# CITY OF PORTLAND, MAINE

## PLANNING BOARD

January 28<sup>th</sup>, 2013

Project Name: **Mixed Use Development at 321 Commercial Street (corner Maple Street)**  
Project ID: 2012-615 CBL: 40-E-3  
Address: 321 Commercial Street  
Applicant: J B Brown & Sons  
Planner: Jean Fraser

DATE: 10-23-12
 SCALE: 1"=20'
 DRAWN BY: EJS
C04
 SHEET: 4 OF 19

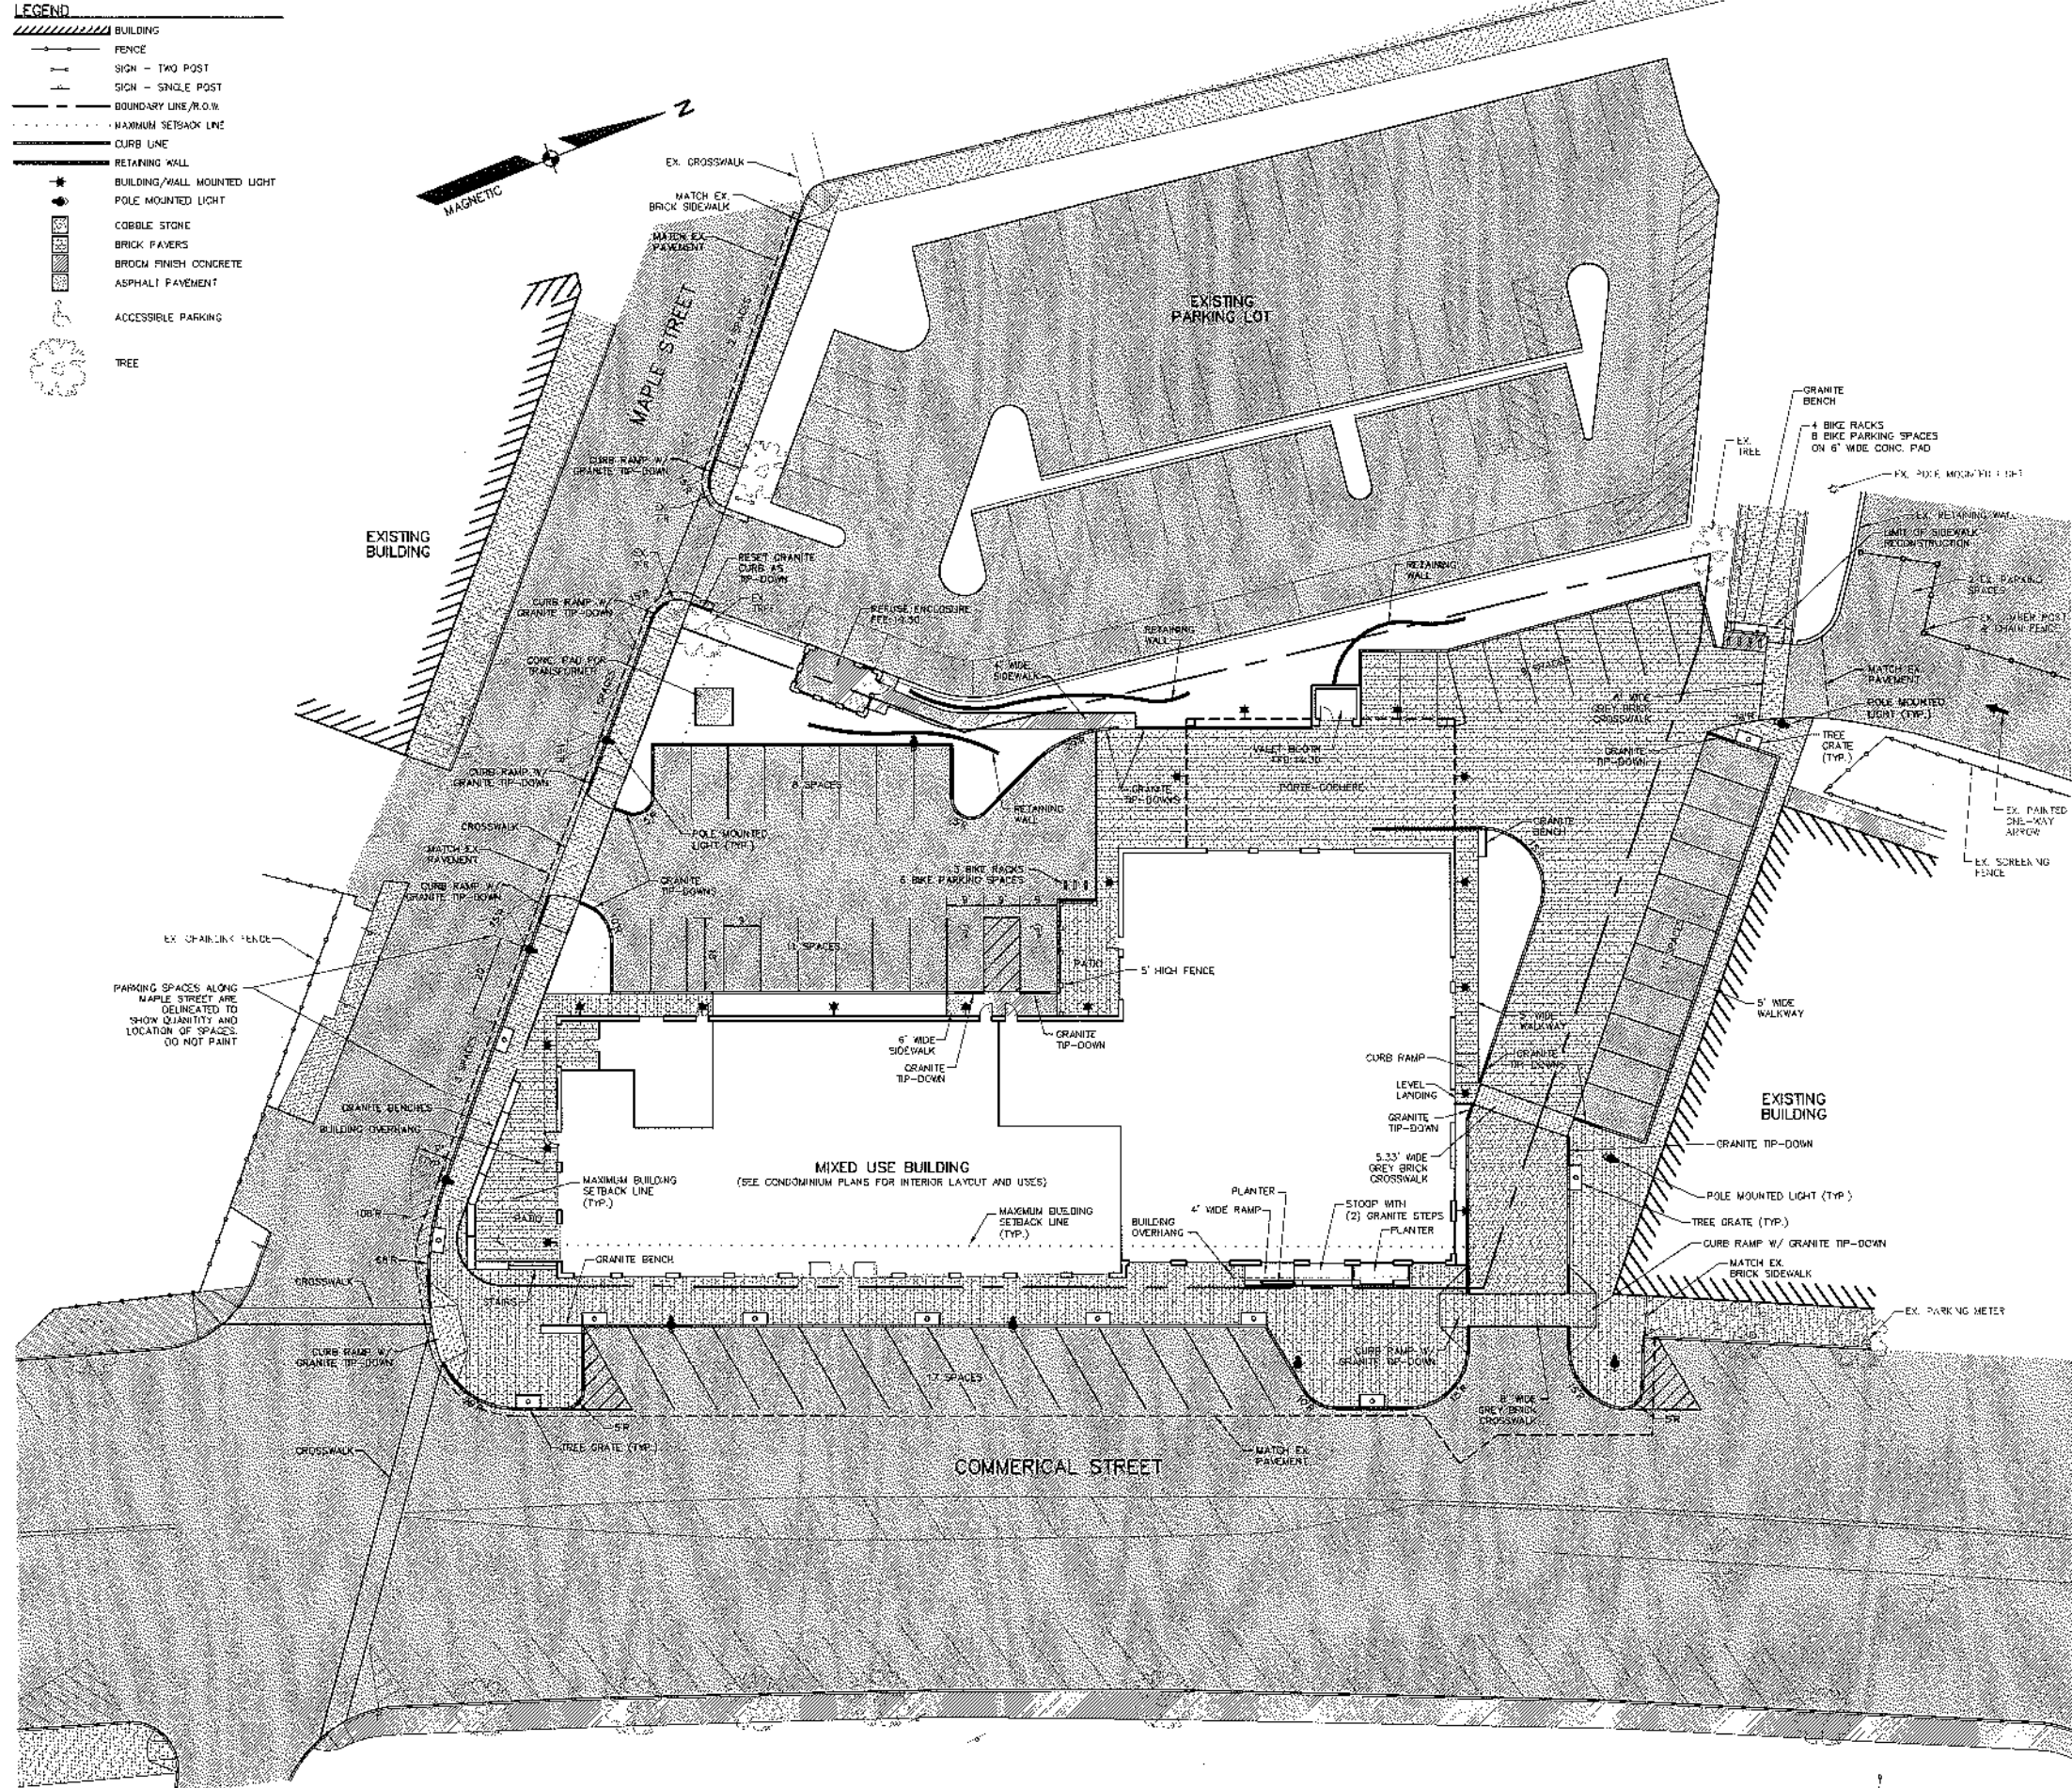
The Planning Board waives Technical Standard, Section 1.20.1, to allow a reduction in the required sight distance to the centerline of the crosswalk on the east side of Commercial Street, subject to the removal of an additional parking space nearest to the crosswalk, as based on Plan CO4 Rev 1.15.2013.

- o **The Commercial Street crosswalk shall not intersect the Maple Street crosswalk at an "apex" location. Separate crosswalk ramps shall be constructed on the project site corner. This change may require some adjustment to the proposed stormwater planter.**

- o **For improved safety it is suggested that an additional parking space be eliminated on Commercial Street abutting the proposed crosswalk. Accordingly, the striped island will need to be expanded.**
- o **The applicant shall install crosswalk warning signs that meet standards in the MUTCD.**
